MECKLENBURG COUNTY  
Park and Recreation Department

MEMORANDUM

**DATE:** July 1, 2024

**RE:** Rezoning Petition #2024-045  
PID# 09904125

**RZ.01**

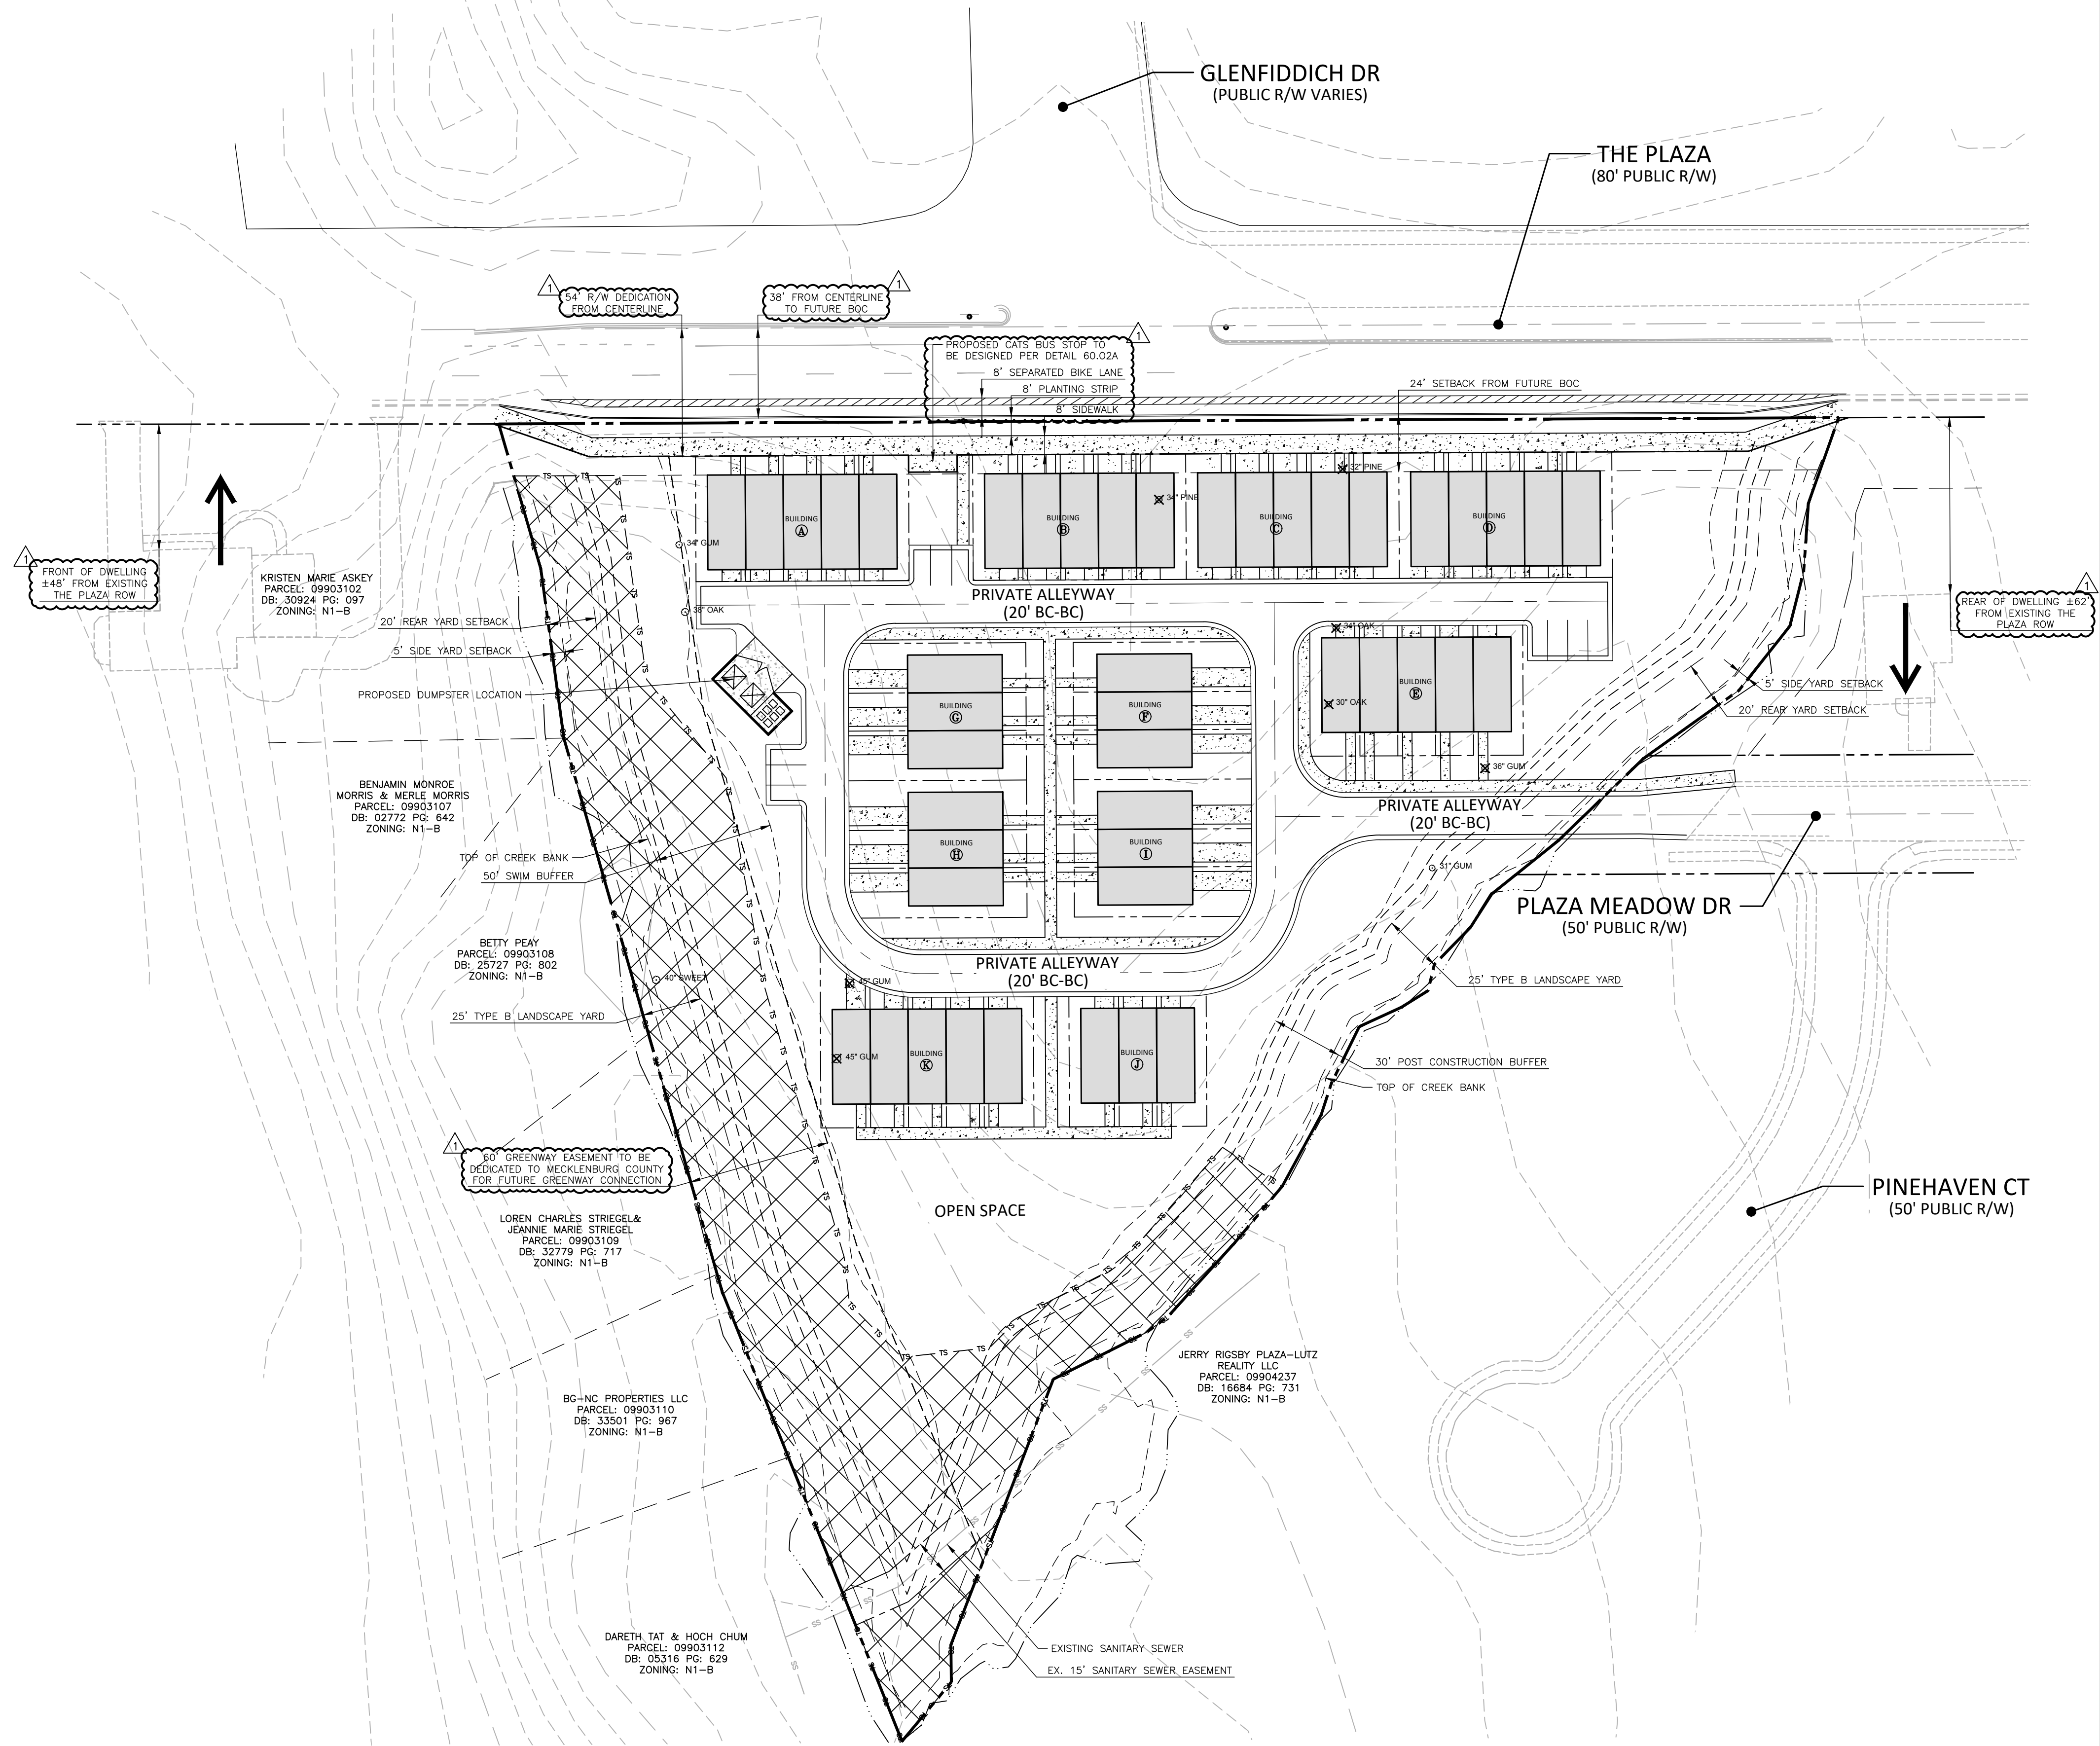
This parcel is on the MCPR Greenway Master Plan. MCPR requests the petitioner dedicate and convey a greenway and storm water easement to Mecklenburg County which would include a minimum of 60' width along the western property boundary, which includes the 50' SWIM Buffer of Briar Creek Tributary. The easement can overlap the tree save areas. The easement should be conveyed prior to the first CO.
